Ribble Valley Borough Council
Planning Section
Council Offices
Church Walk
Clitheroe
BB7 2RA

Planning Application No: 3/2026/0286

Proposal: Proposed construction of a detached garage in the front garden.

Location: 53 Knowsley Road Wilpshire BB1 9PN

| V9-GA-002 | |

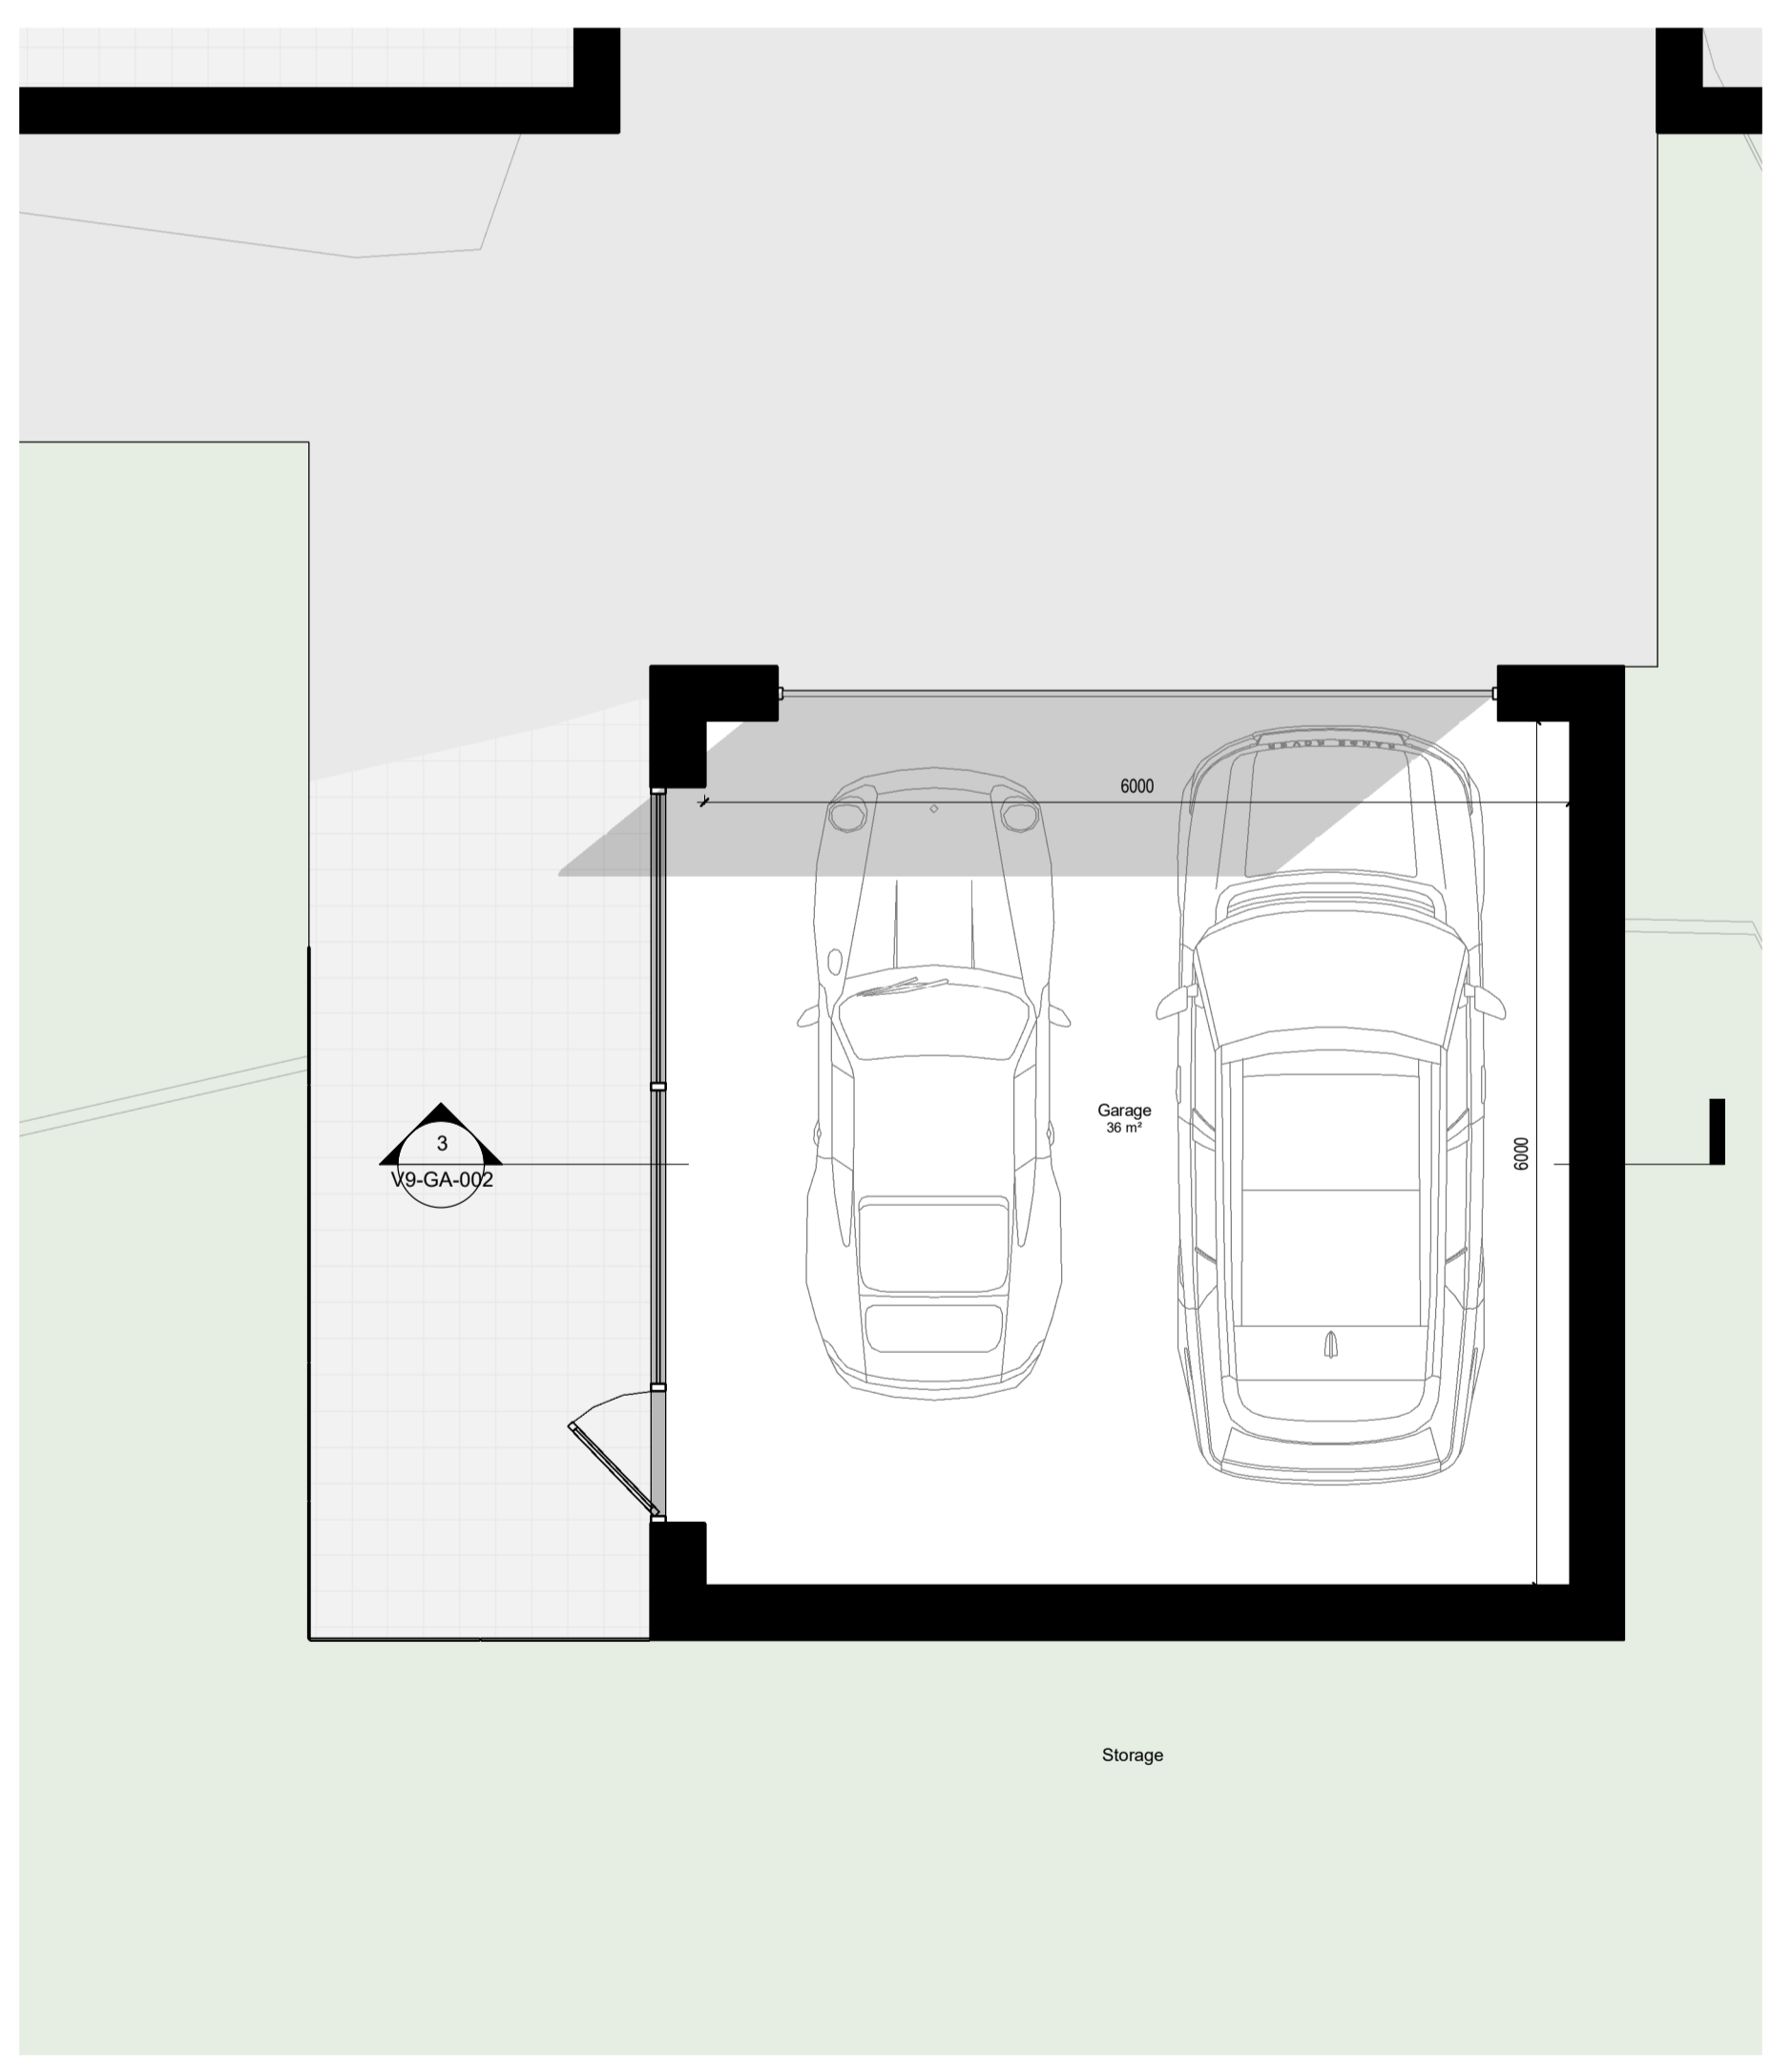
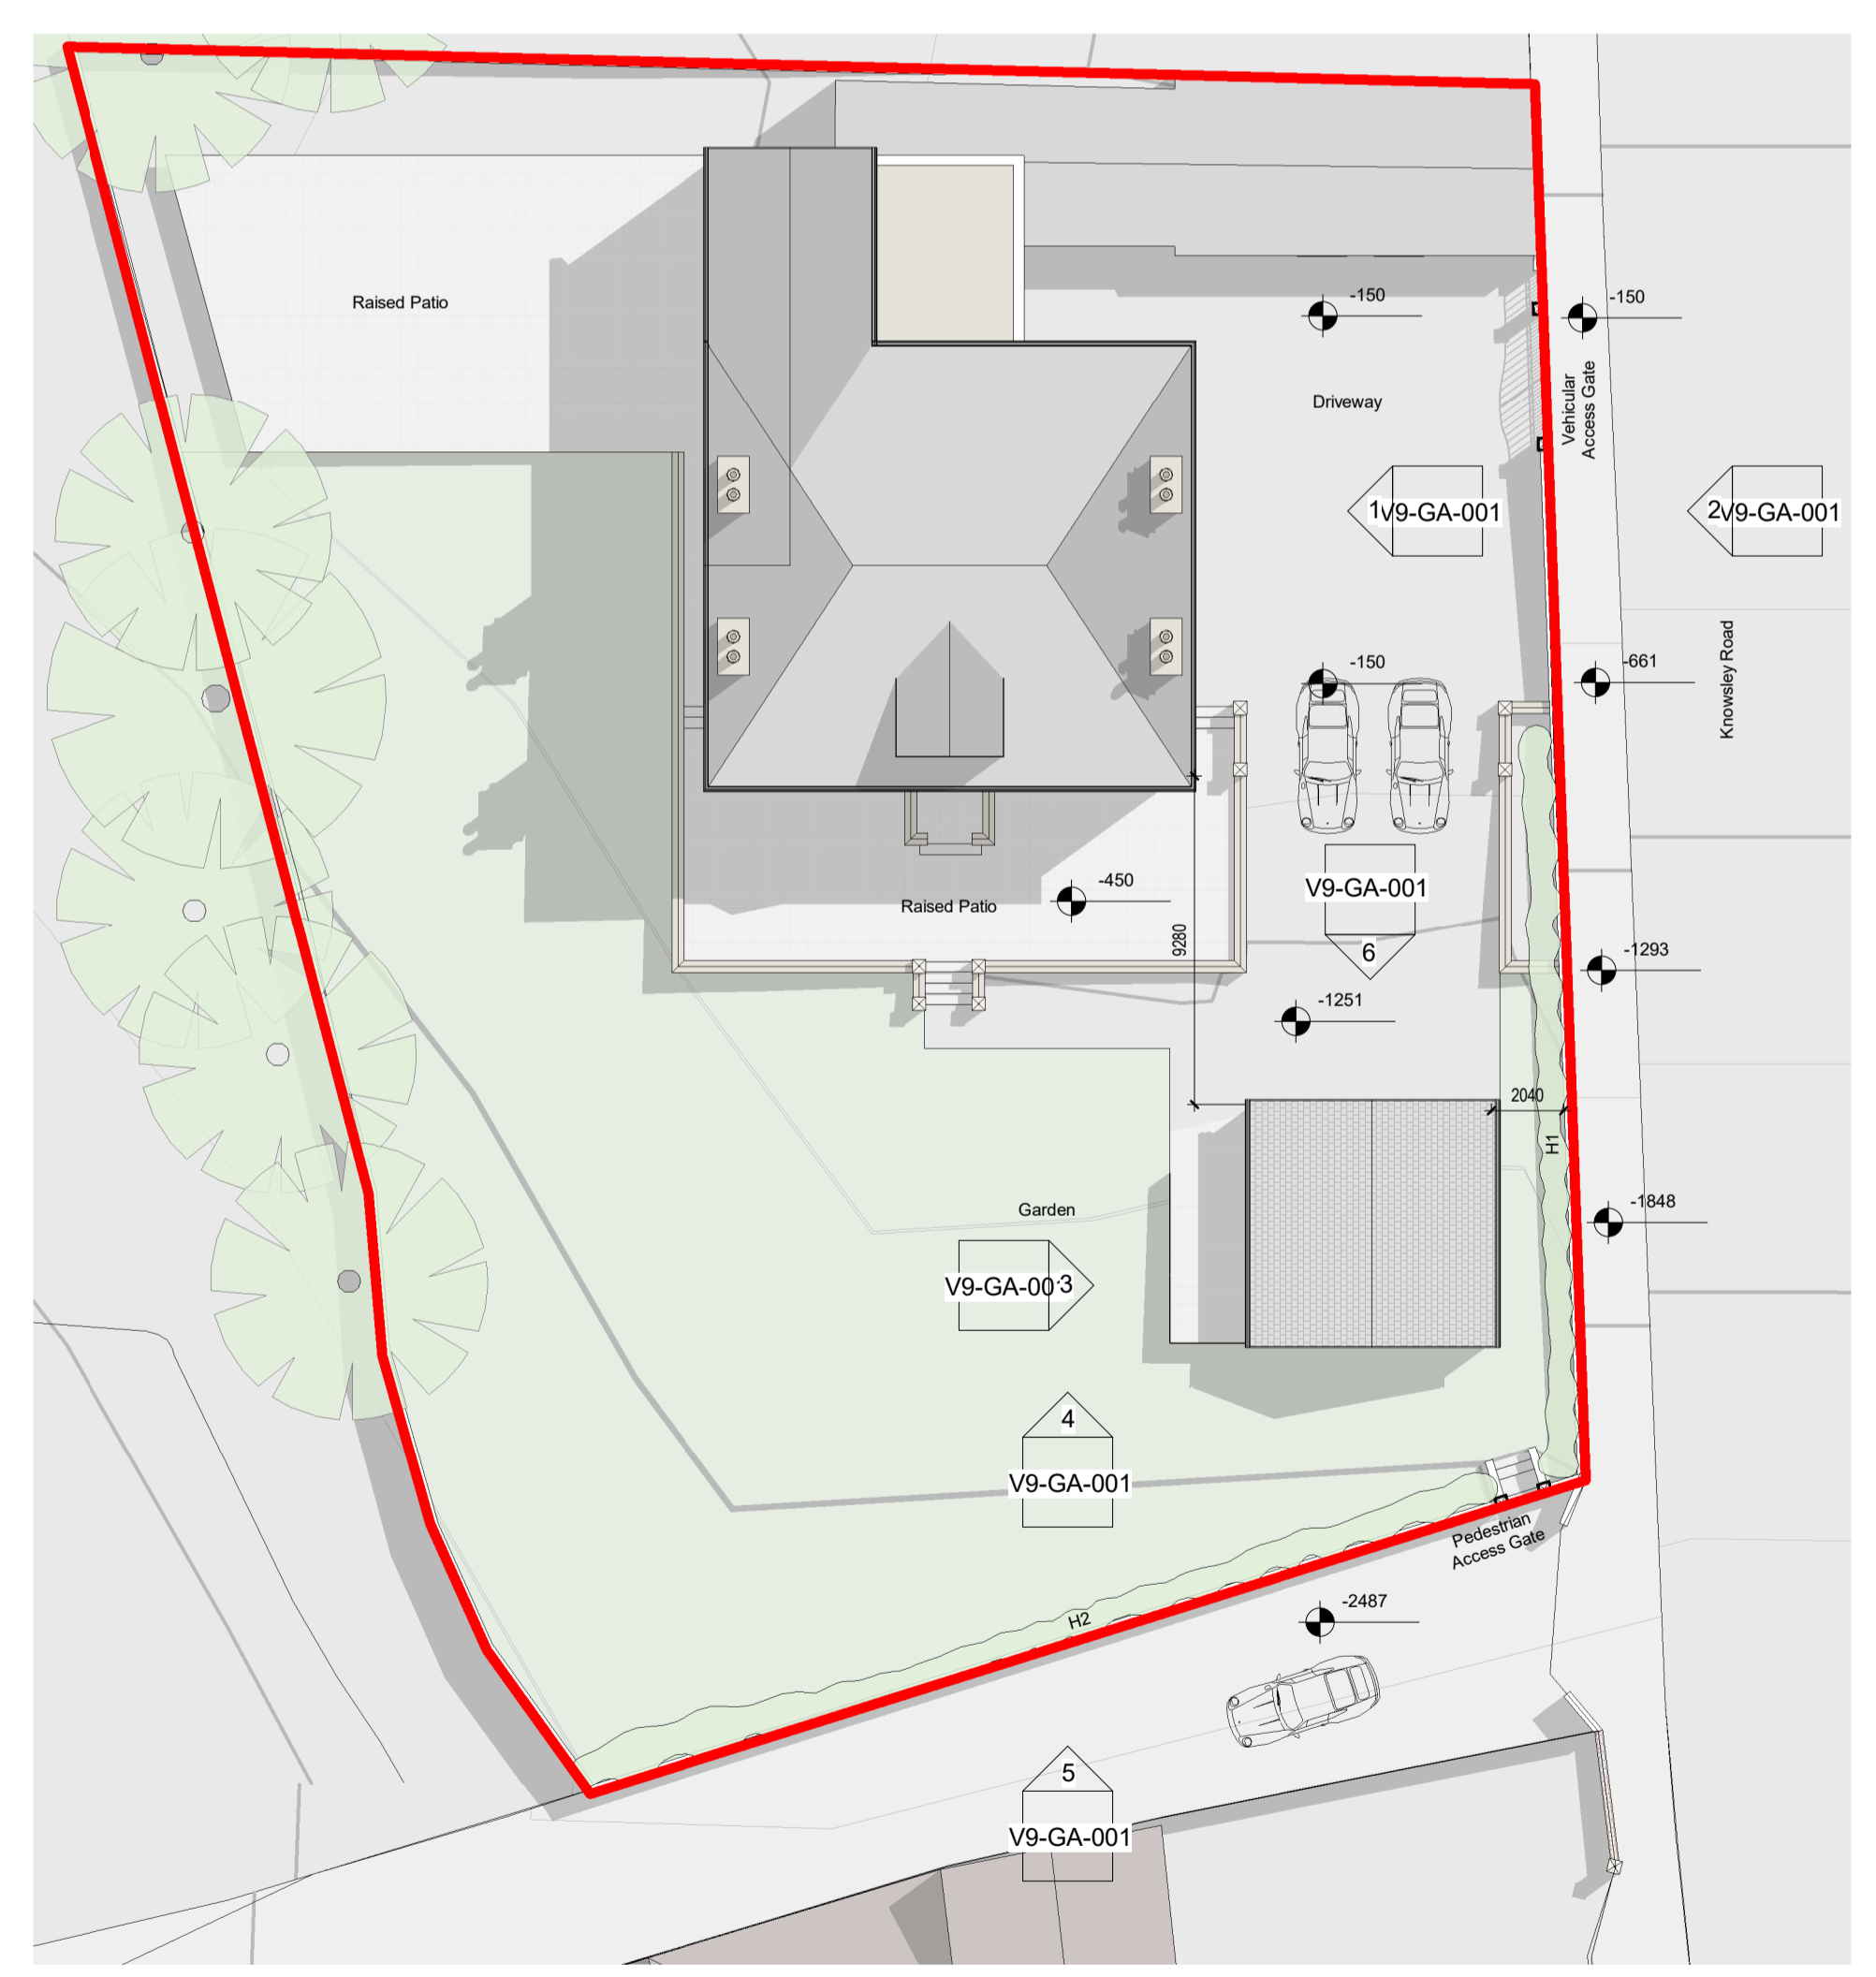
Our comments on application no. 3/2025/0887 remain. Ref. Drawing V9-GA-002 (18/4/2026) submitted is acceptable.

The site will retain the existing access onto Knowsley Road, the C543, with a speed limit of 20 mph fronting the site access. The proposed garage is set back into the site 2m from Knowsley Road and 2m from the private access drive running to the south of the site which serves 4 dwellings.

The footways along Knowsley Road are approximately 2m wide and the proposal does not impact the existing visibility splays for the existing access or the nearby residential access to the south. The proposal will retain the existing driveway area, and the garage will provide additional parking. There is room to turn within the site, allowing for ingress and egress in forward gear. The recommended minimum internal dimensions for a single garage size is 6m in length and 3m wide. The recommended distance of 6m is based on the length of a large family car (Ford Mondeo Estate 4.58m long), clearance at the rear of the car (200mm), overhang of the garage door (600mm) and room to stand in front of the car and open/close the garage door (600mm).

The proposed garage meets the recommended minimum dimensions to provide 1 off street parking space. Should you wish to support the application, we would request that the following condition be added to the decision notice:

1. The garage hereby approved shall be kept available for the parking of vehicles ancillary to the enjoyment of the household and shall not be used for any use that would preclude the ability of their use for the parking of private motor vehicles, whether or not permitted by the provisions of the Town and Country Planning (General Permitted Development) Order 2015 or any order amending or revoking and re-enacting that order.
Reason: To ensure that adequate parking provision is retained on site.
